Date: 14 July 2026

Below are the comments of Derbyshire County Council in response to the application for non-material changes relating to Oaklands Farm Solar, EN010122.

SUBSTATION BUILDING  
TOP VIEW

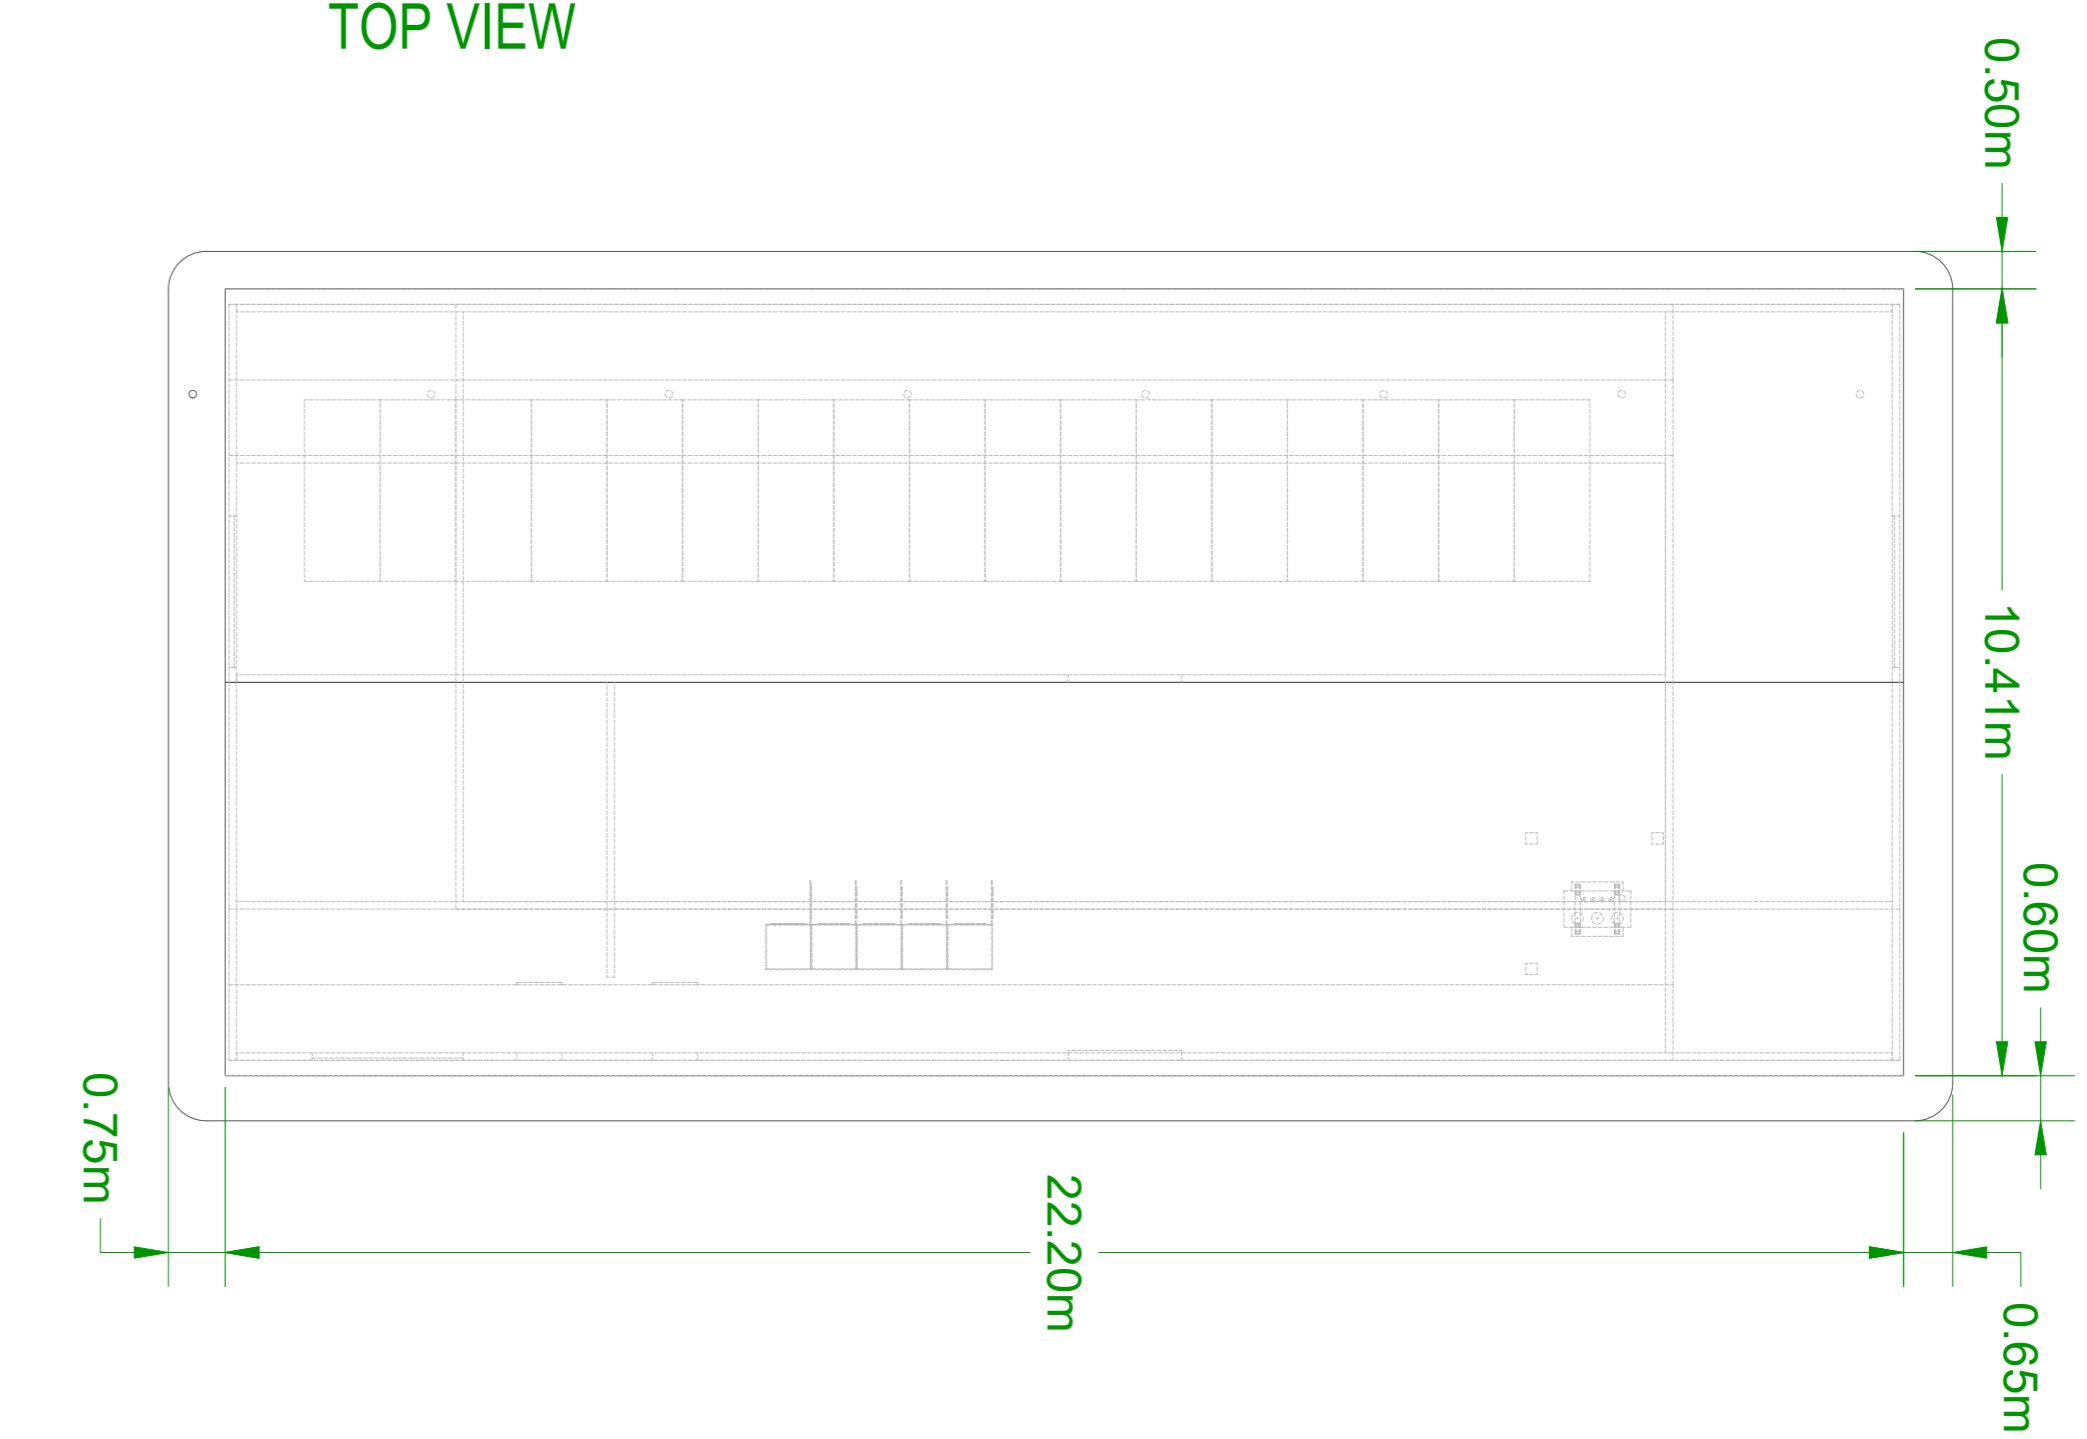
Change 4 – Substation - The original parameters allowed for a maximum dimension of 7.2m x 5.3m x 3.7m (length, height, width) for the substation transformer but does not specify if this comprises the fully assembled transformer with the additional electrical paraphernalia attached to the main body of the transformer. Therefore, for clarity and avoidance of doubt

the parameter is now proposed to be 8.3m x 6m x 5m (length, height, width) which represents the maximum parameters of the substation transformer fully assembled, including its additional electrical paraphernalia. The height of the assembled transformer remains below the tallest part of the substation which is the Overhead Busbar at a height of 7.4m. In addition, the concrete blast wall is to be increased from 5.2m in height to 6.3m for safety reasons.

In addition, the foundation depths of the Welfare Unit and Storage area are to increase from 0.1 to 0.6m and the foundation depth of the statcom will increase from 50mm to 1m.

While it is accepted that the changes proposed to the parameters of the substation are for clarity, the increase in height of the blast wall, by 1.1m, and in increase in depth of the foundations are considered material, particularly in light of the importance placed on visual impacts, land drainage and the potential to return to site to agricultural use on decommissioning during the EiA.
